Planning comments - V1  
Matthew Fitzsimmons - 8/31/22

# Romens Subdivision

Final Plat

## FINAL PLAT LETTER OF INTENT ROMENS SUBDIVISION

FINAL PLAT

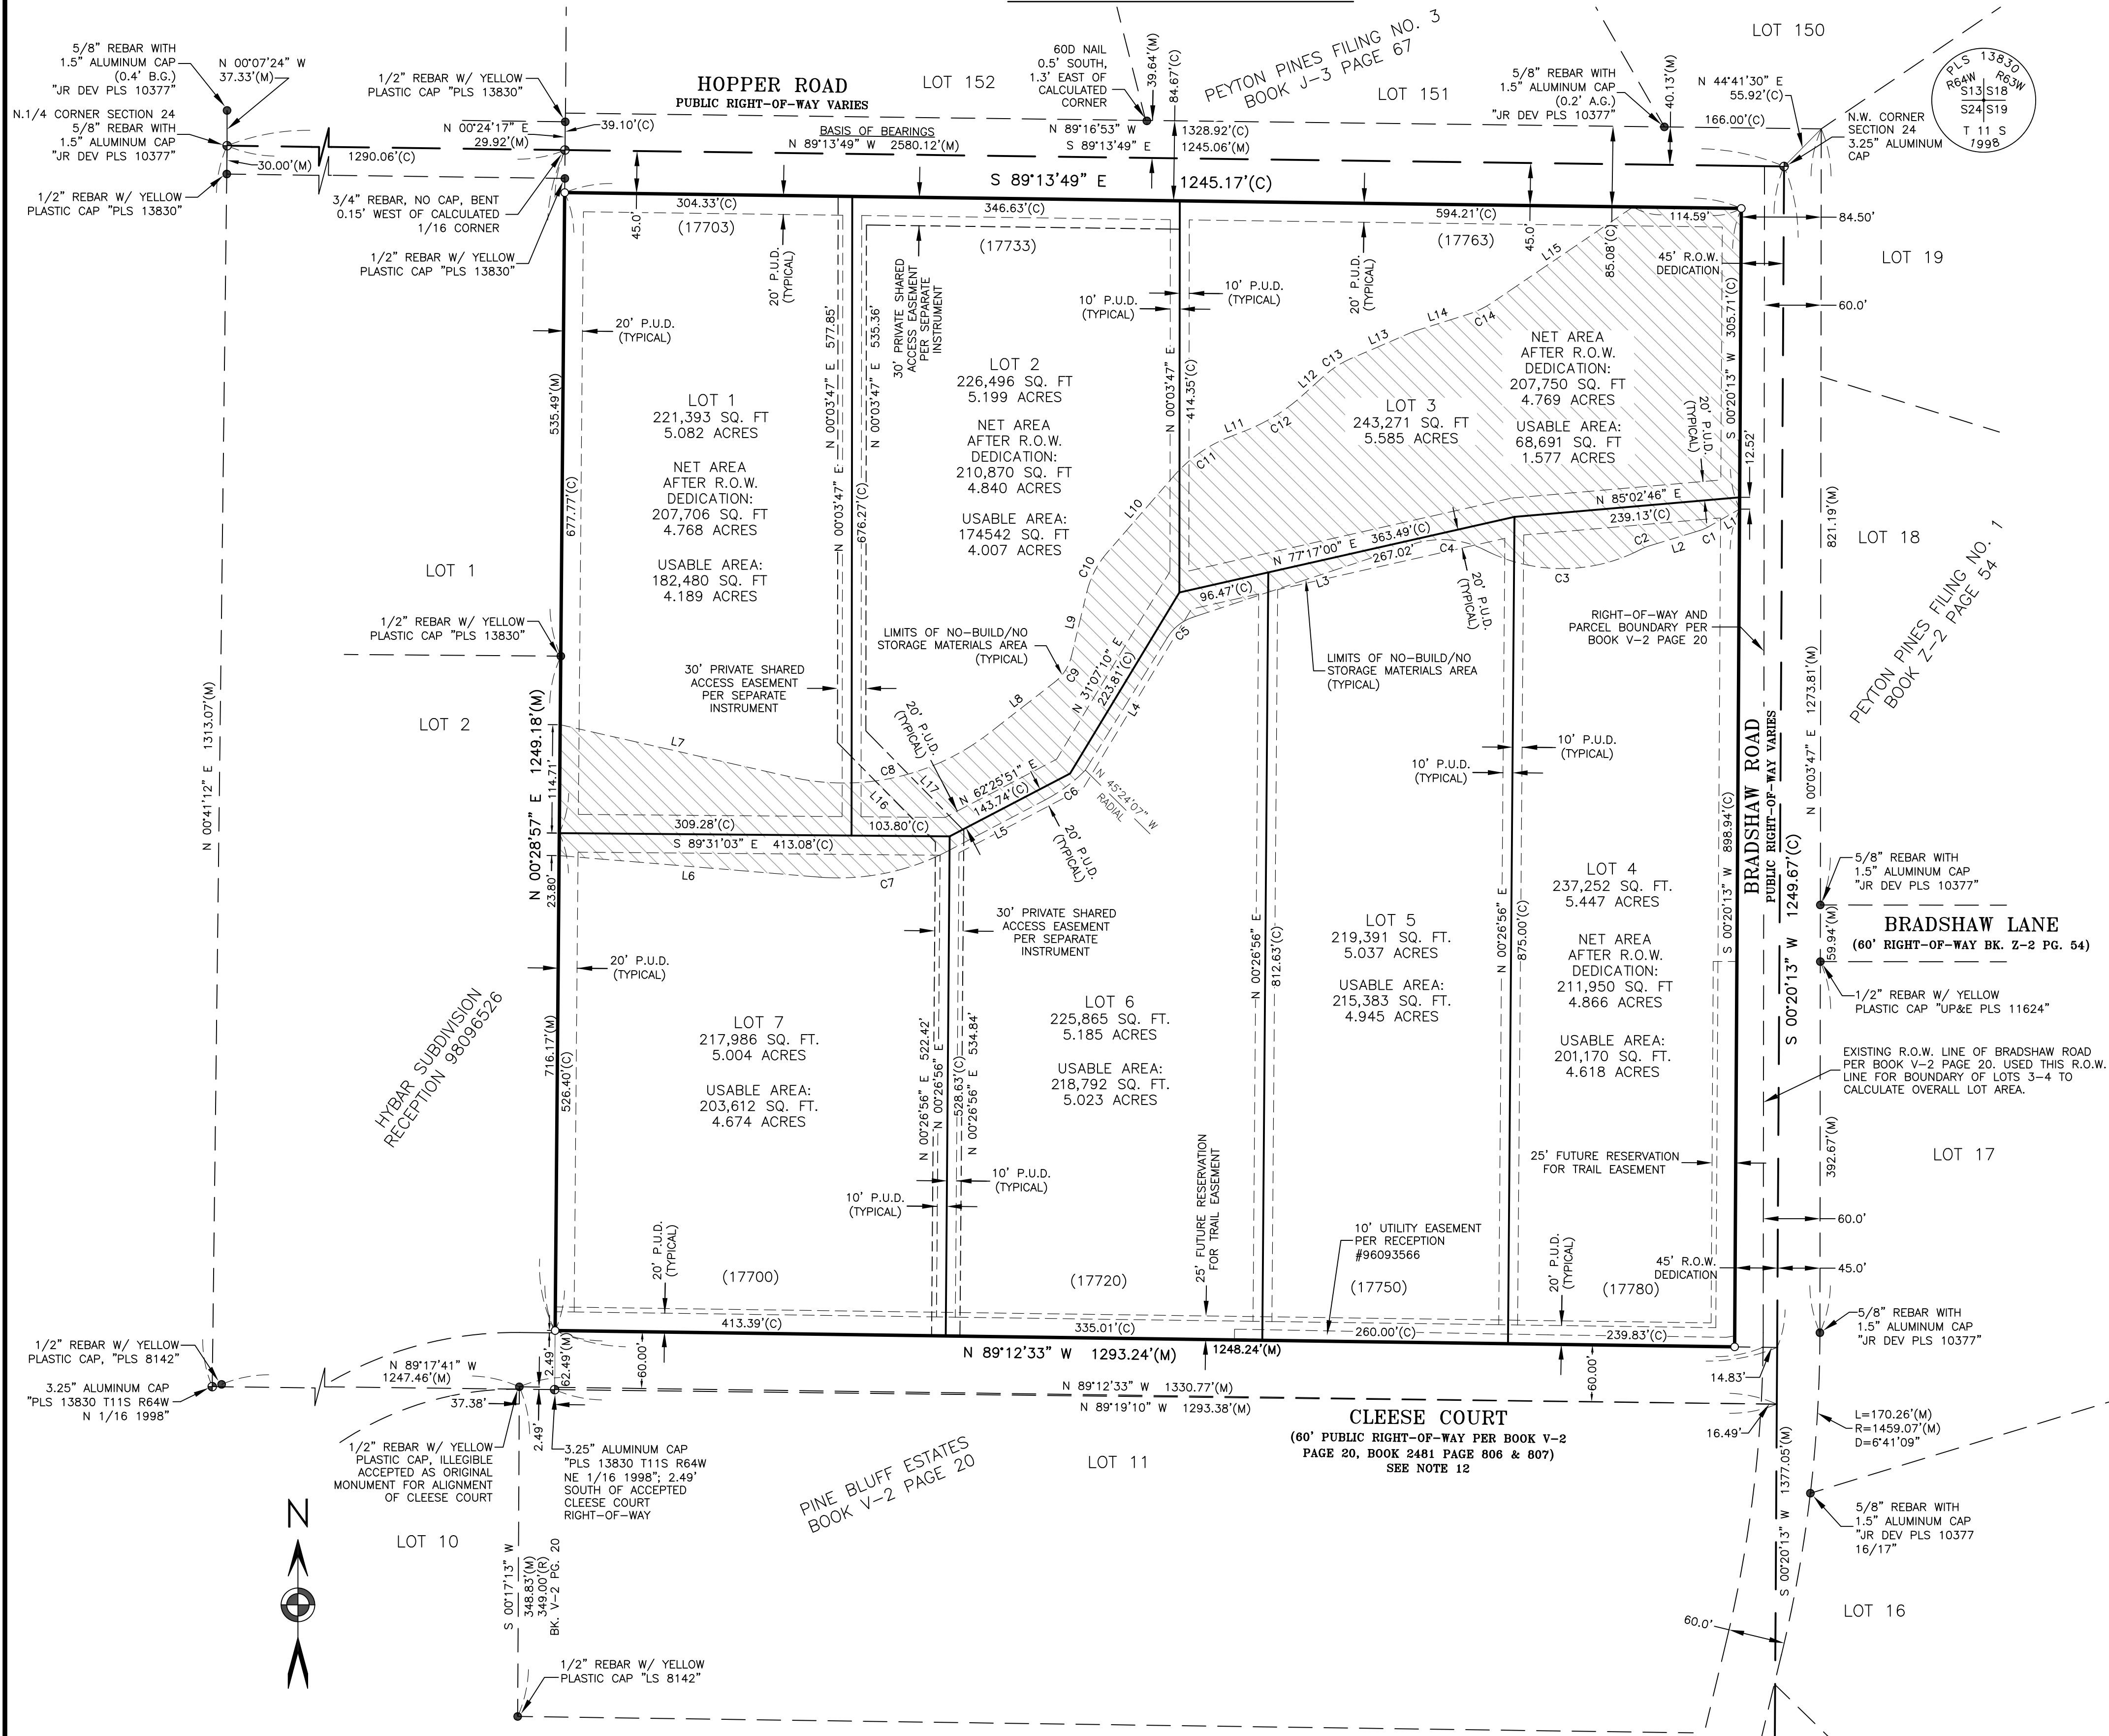
Explain in the letter of intents to be included within a Public Improvement District (PID). If electing not to be in PID remove plat note 29.
